Our ref: STH17/00137/02
Contact: Rachel Carocci 4221 2423
Your ref: SSD8667

STATE SIGNIFICANT DEVELOPMENT 8667 – LOTS 1-10 SEC 46 DP 758468 & LOT 1 DP 133606, 130 GOLDSMITH ST, GOULBURN – REDEVELOPMENT OF GOULBURN BASE HOSPITAL

Roads and Maritime Services (RMS) refers to your correspondence dated 19 March 2018 regarding the subject development application.

DESCRIPTION  
SOUTHERN  
ENTRANCE

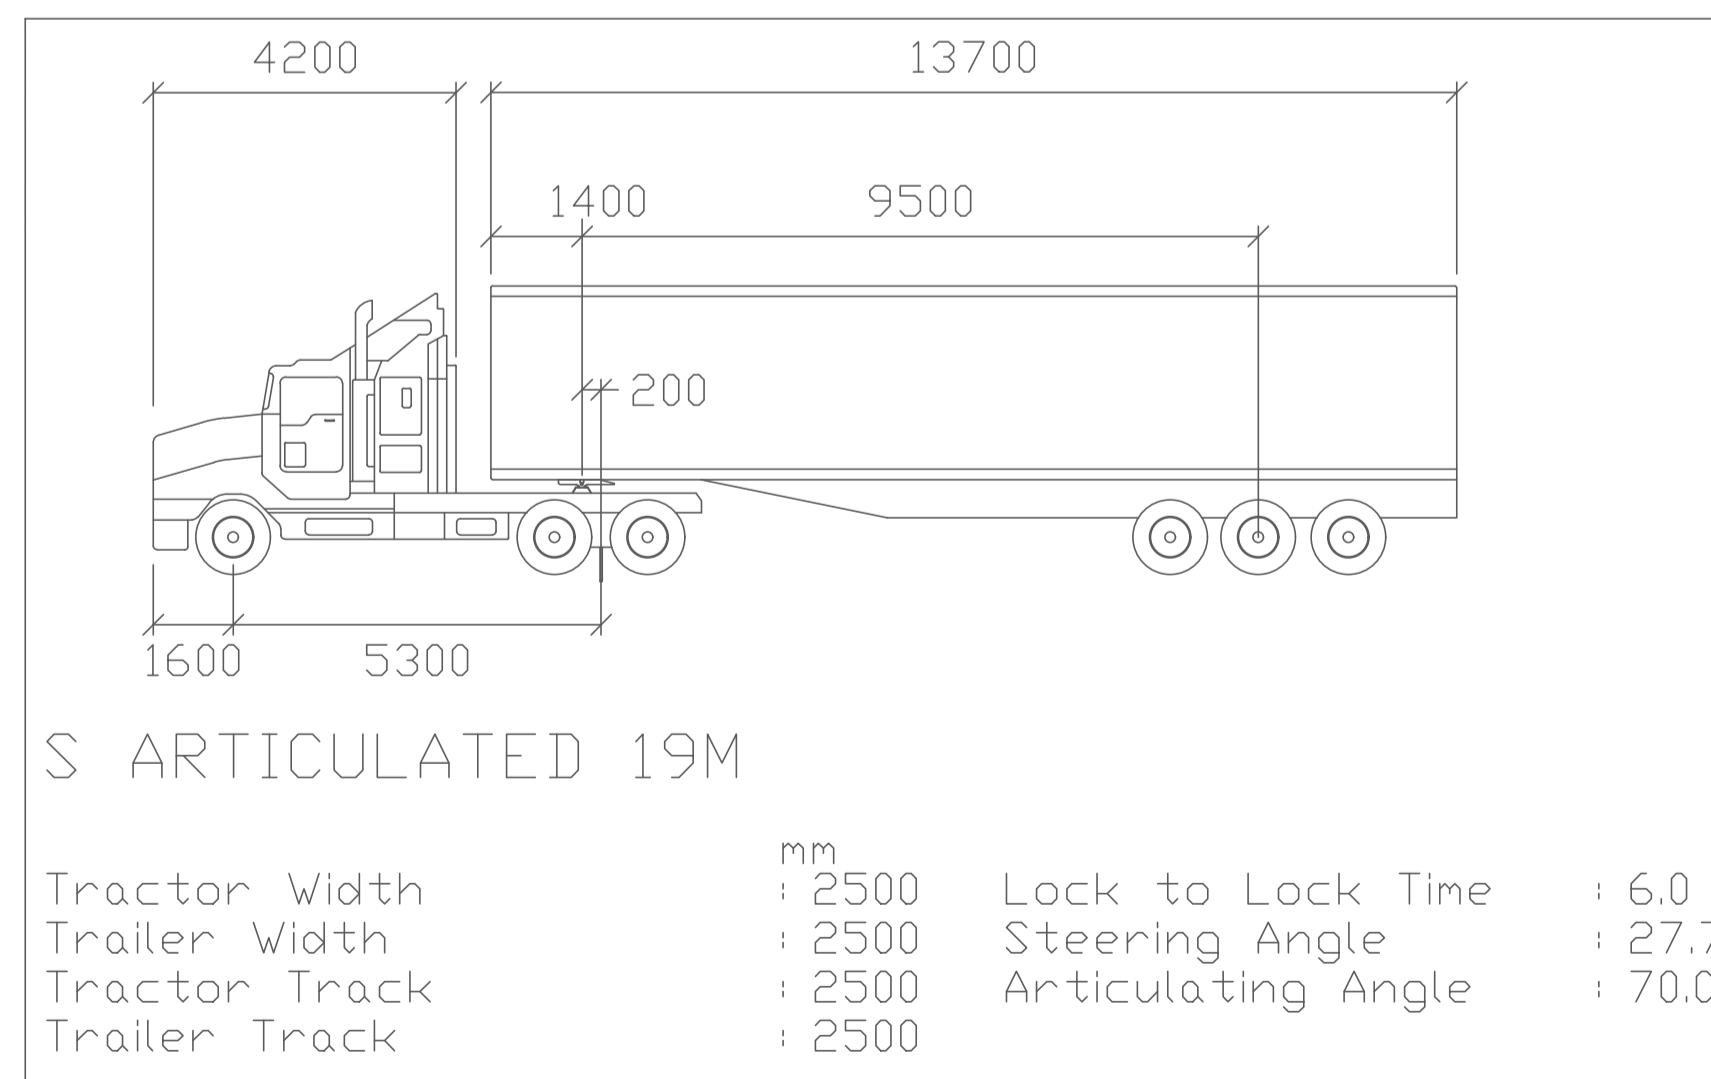
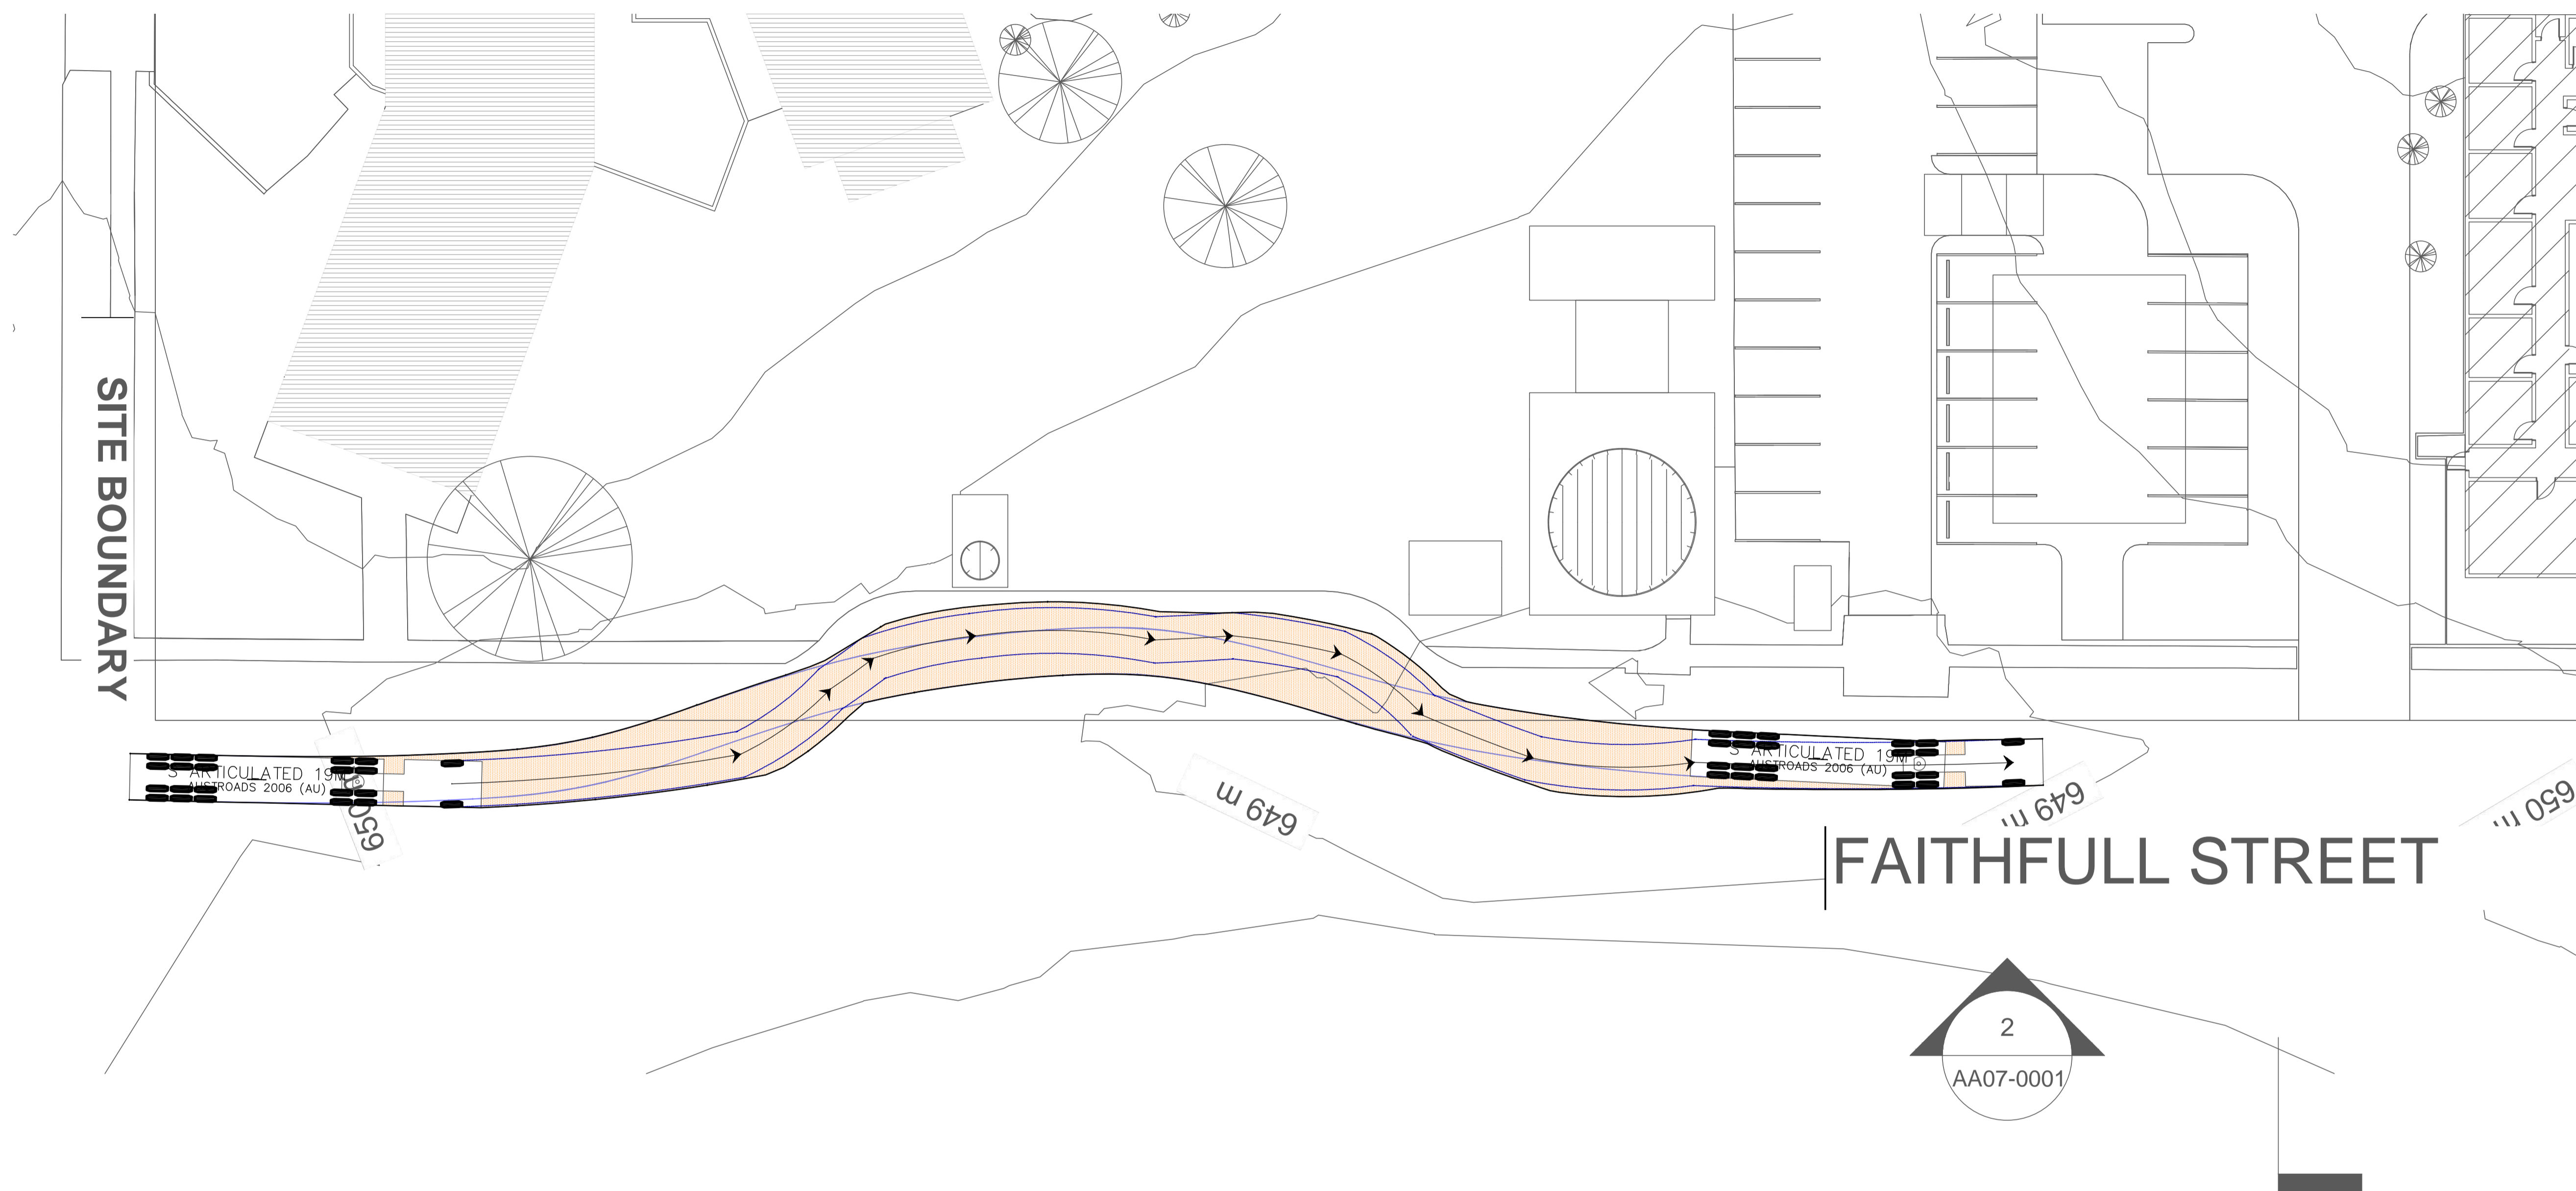
- The Environmental Impact Statement states vehicular access is proposed via new driveways from Goldsmith Street. RMS is unclear of the proposed works as the plans only show the existing three access points off Goldsmith Street, eg. the entrance and exit points for the patient drop off facility and the eastern entrance on Goldsmith Street.
- A scaled plan is required showing the existing and proposed access arrangements at Goldsmith Street.
- RMS also requires a scaled plan to show the proposed new car parking facilities at Goldsmith Street. Proposed car parking facilities should be compliant with *Australian Standards 2890.1*.
